ELLICOTT TOWN CENTER

Filing No. 1

Construction Drawings El Paso County, Colorado

SHEET: TY2

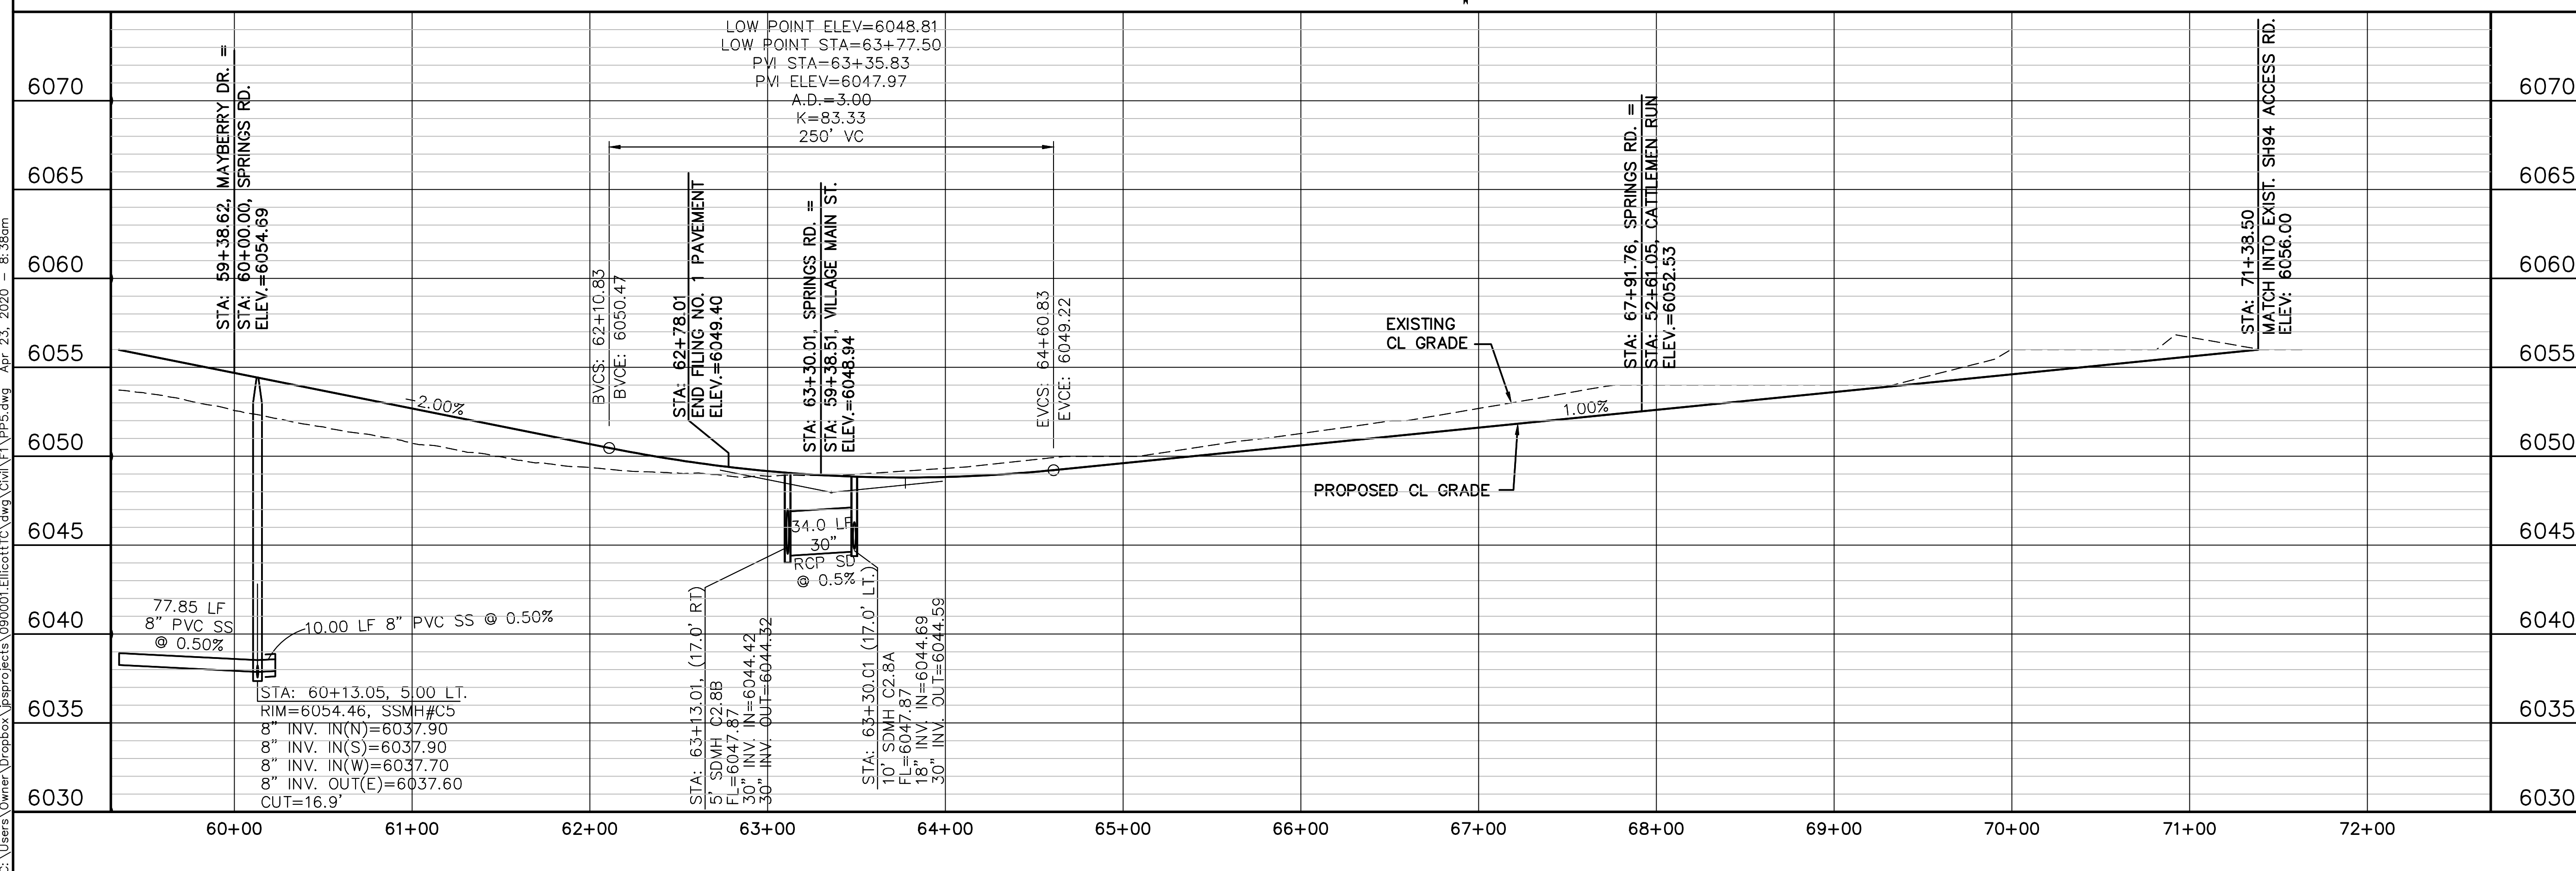
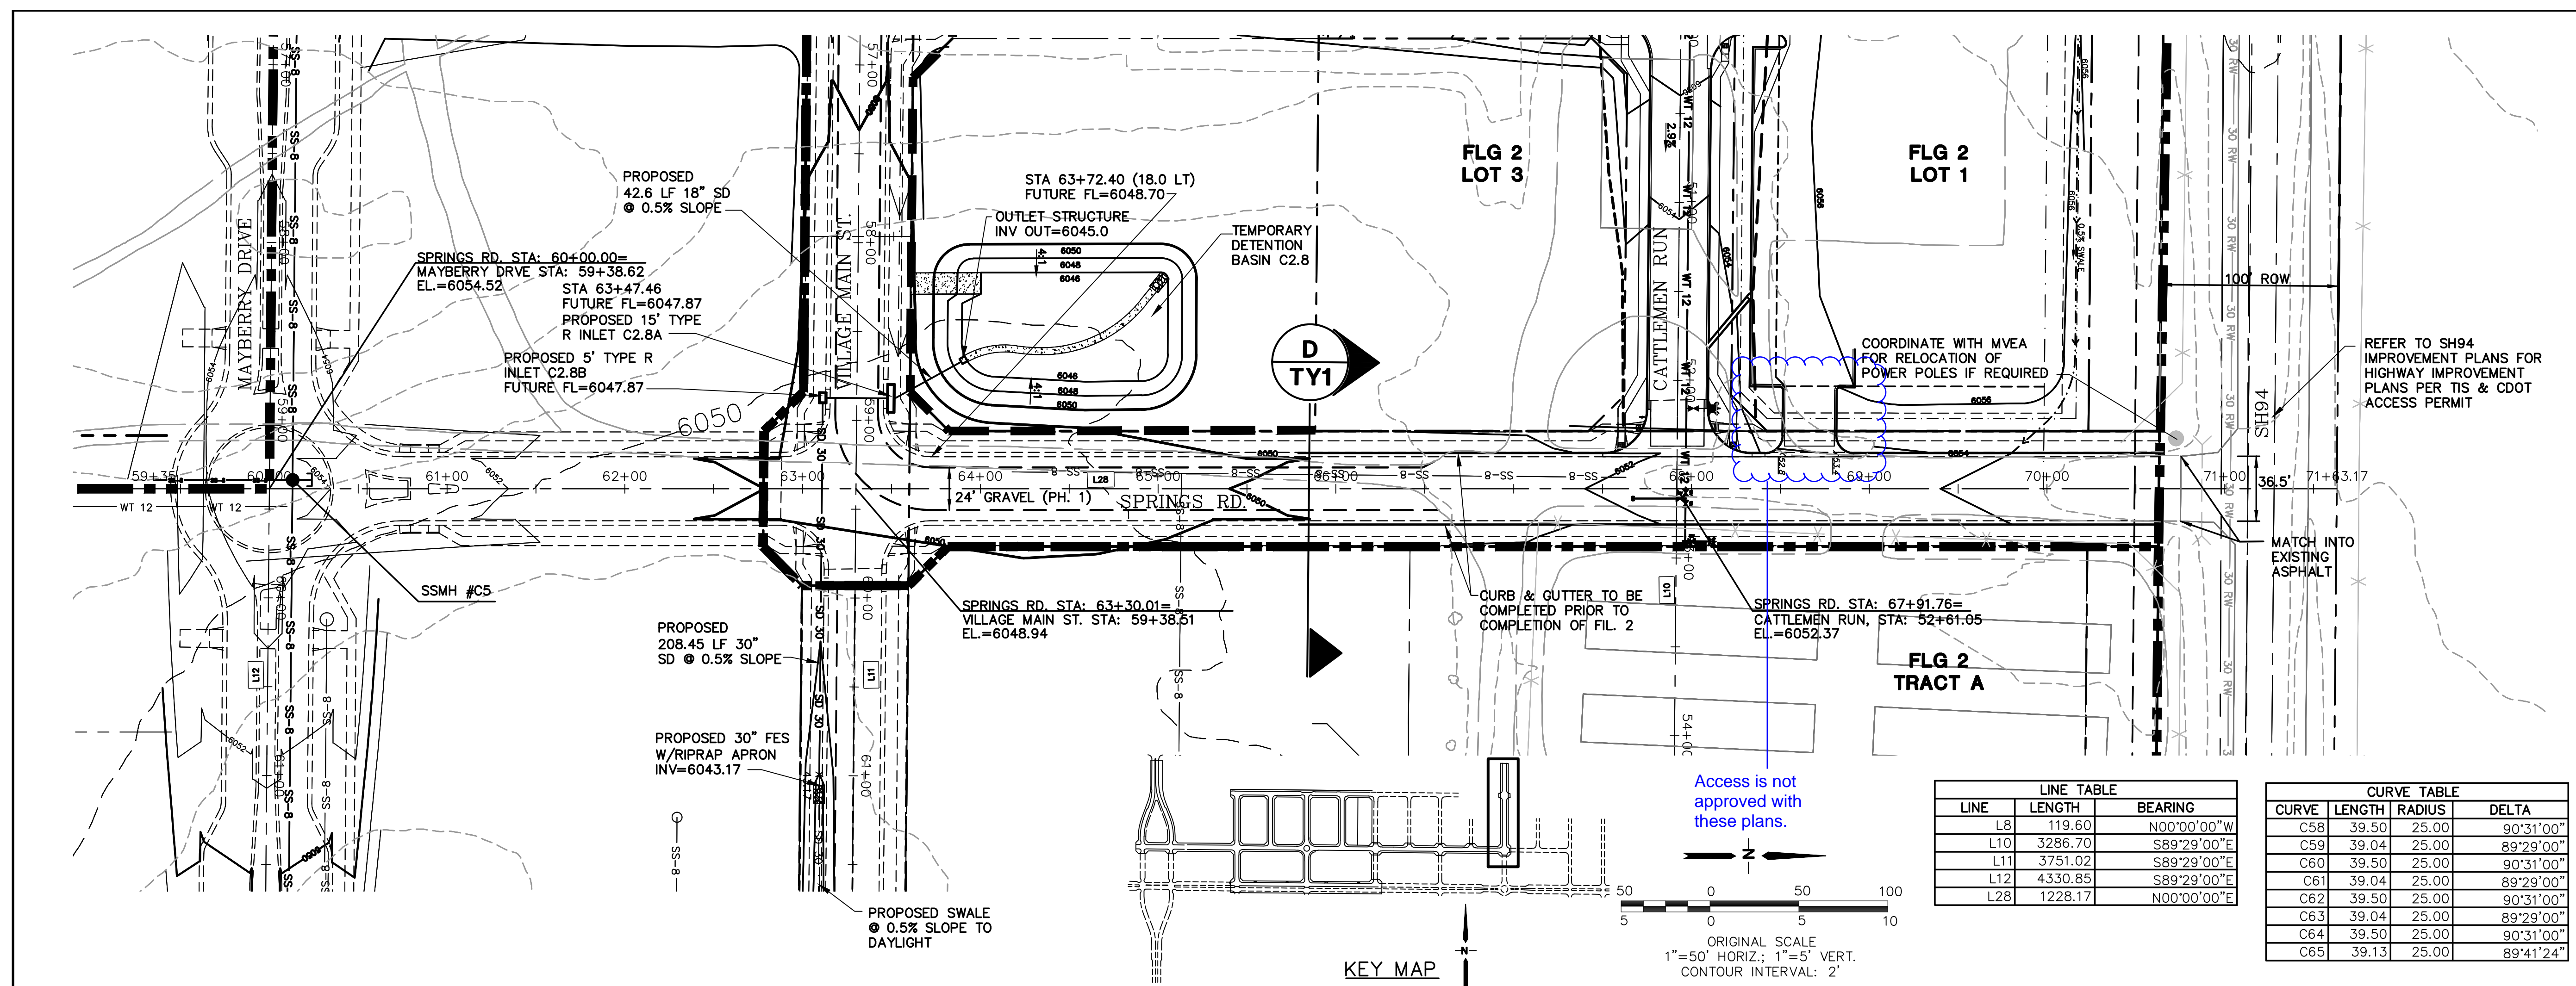
Is this right?

Move to cross-section sheets, provide for all cross-sections.
